Mountain View Electric Association, Inc. (MVEA) has these comments about the following:

Project Name: Woodard Minor Subdivision

Project Number: MS 197

Description: A two (2) lot residential subdivision is proposed for an approximately 14 acre parcel located south of Vessey Road and west of Black Forest Road. This proposed subdivision is also known to be in Section 06, Township 12 South, Range 65 West.

WOODARD SUBDIVISION

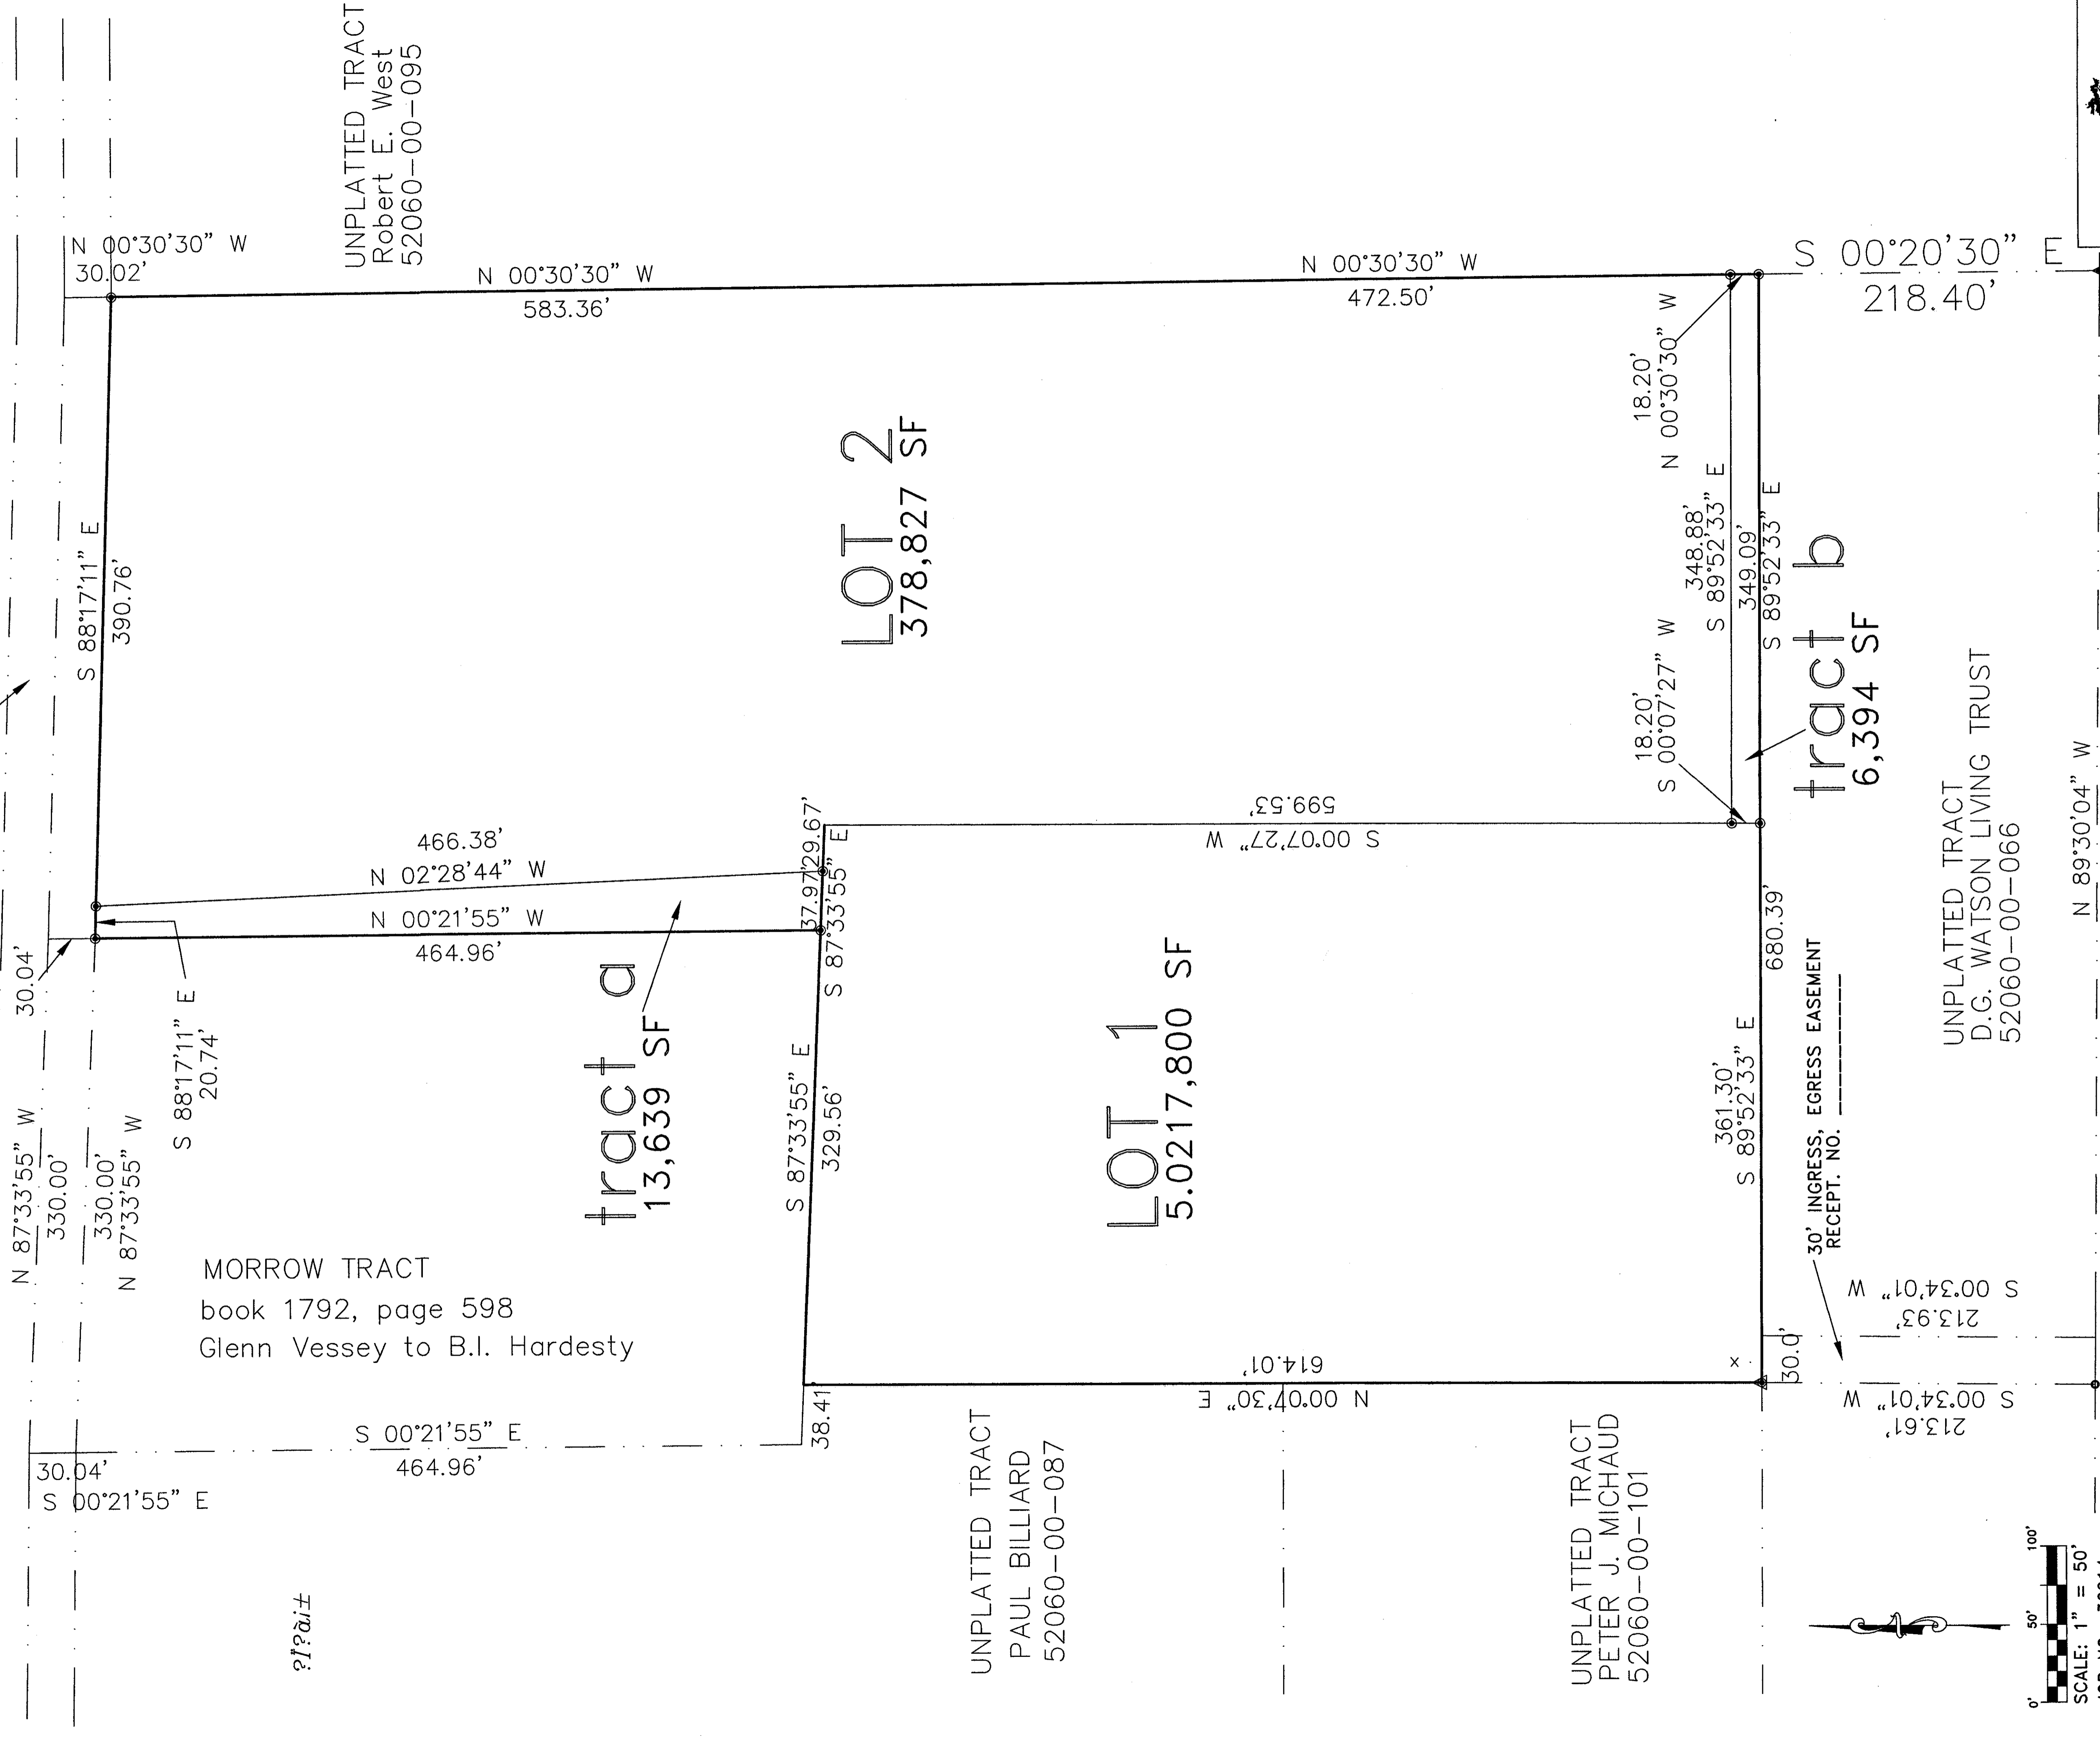
MVEA request utility easements of ten (10) foot common side lot line along with twenty (20) foot exterior utility easement. MVEA also requests platting of existing MVEA facilities with easement on the plat. Additional easements may be required in order to serve this development.

MVEA has existing facilities within this parcel of land. If there is any removal or relocation of facilities it will be at the expense of the applicant.
